DEVELOPMENT REVIEW BOARD  
SUPPLEMENTAL SUBMITTAL

PROJECT NO. PR-2021-005628

Re: PR2021-005628 – Request for Preliminary Plat: Mesa Del Sol Innovation Park City Center

CONCEPTUAL UTILITY PLAN			
MDS CITY CENTER			
DRAWN BY:	AO	DATE:	11/11/2021
CHECKED BY:	MJB	BHI PROJECT NO.	20220088
		SHEET NO.	1 OF 1

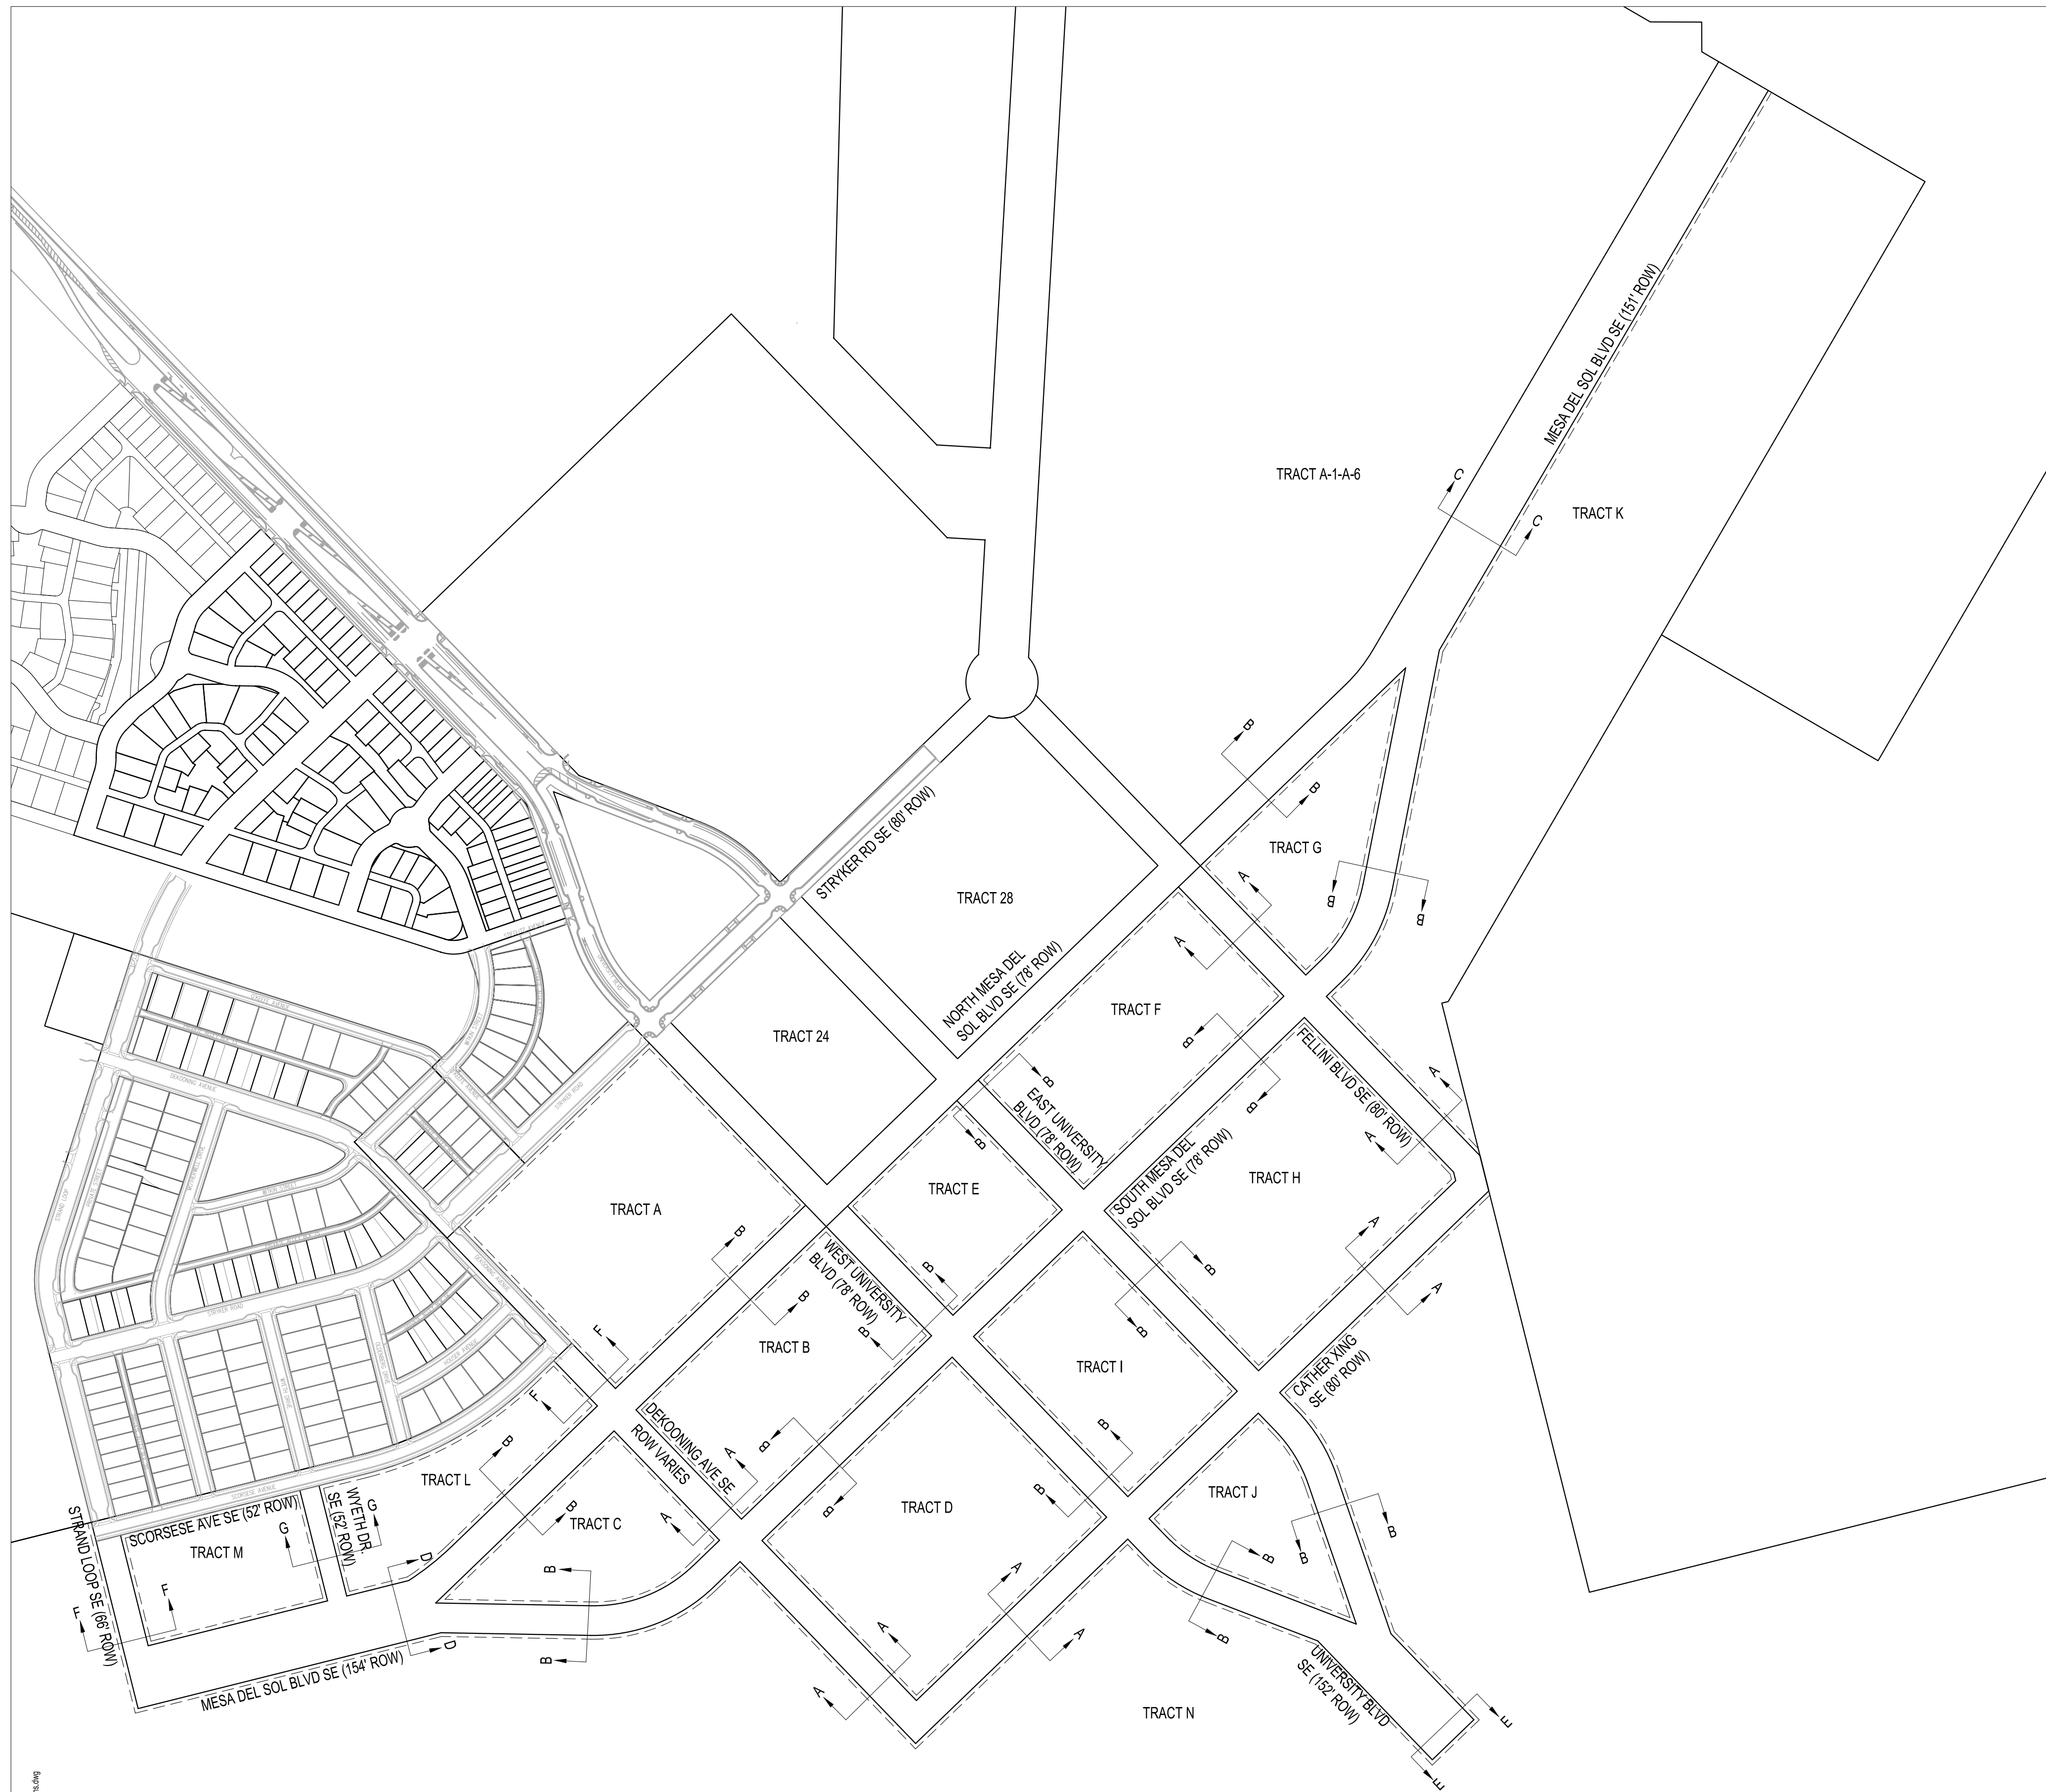
*2 – Serviceability Letter #211028 is in processing and will set the criteria for service. An executed serviceability letter is required prior to approval to identify the required infrastructure for the platting action.*

*b. The current utility plan and infrastructure list match the draft serviceability letter.*

Response: We received Serviceability Letter and updated the infrastructure list and Conceptual utility plan accordingly.

Response: See attached for the latest Infrastructure list and Conceptual Utility plan.

D TYPICAL STREET SECTION - MESA DEL SOL BLVD
(WEST OF WESTERN CORRIDOR)

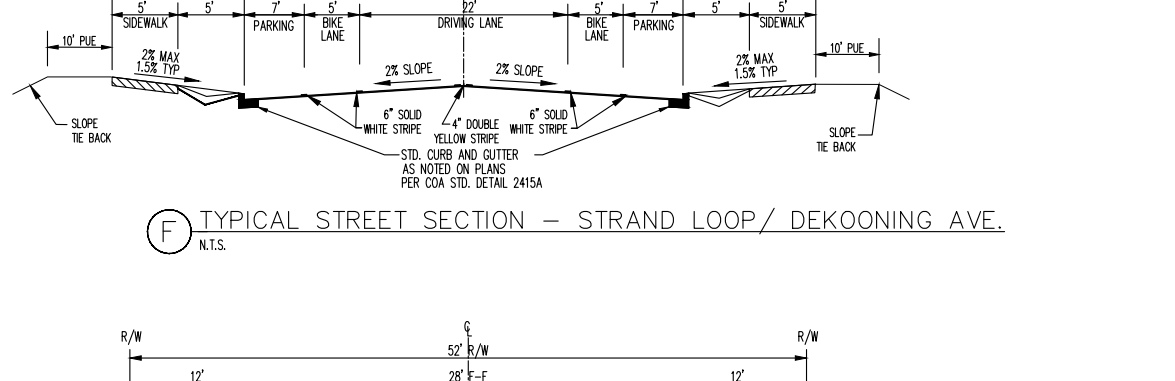
*3 – 02-09-2022: Given recent discussions, one side of Mesa del Sol Blvd west of western couplet could implement a multi-purpose trail in lieu of a 5-ft sidewalk to connect to the multi-purpose trail east of the eastern couplet along Netflix, and to connect westward toward I-25. Can Section D be revised to allow for a multi-purpose trail on one side of the road?*

*4 – 03-02-2022: Regarding street section D / Mesa del Sol Blvd west of western couplet, please consider switching dimensions outside of curb to 15-ft for side with multi-use trail and 13-ft for side with sidewalk.*

*5 – 03-30-2022: Please confirm the proposed Multi-Use Trail on Mesa del Sol Blvd, West of Western Couplet, is positioned on the north side of the street.*

Response: The dimension was switched to allow for a 15' for the multi-use trail and 13-ft for the side with sidewalk.

Response: The multi-use trail is now positioned on the north side of the street.
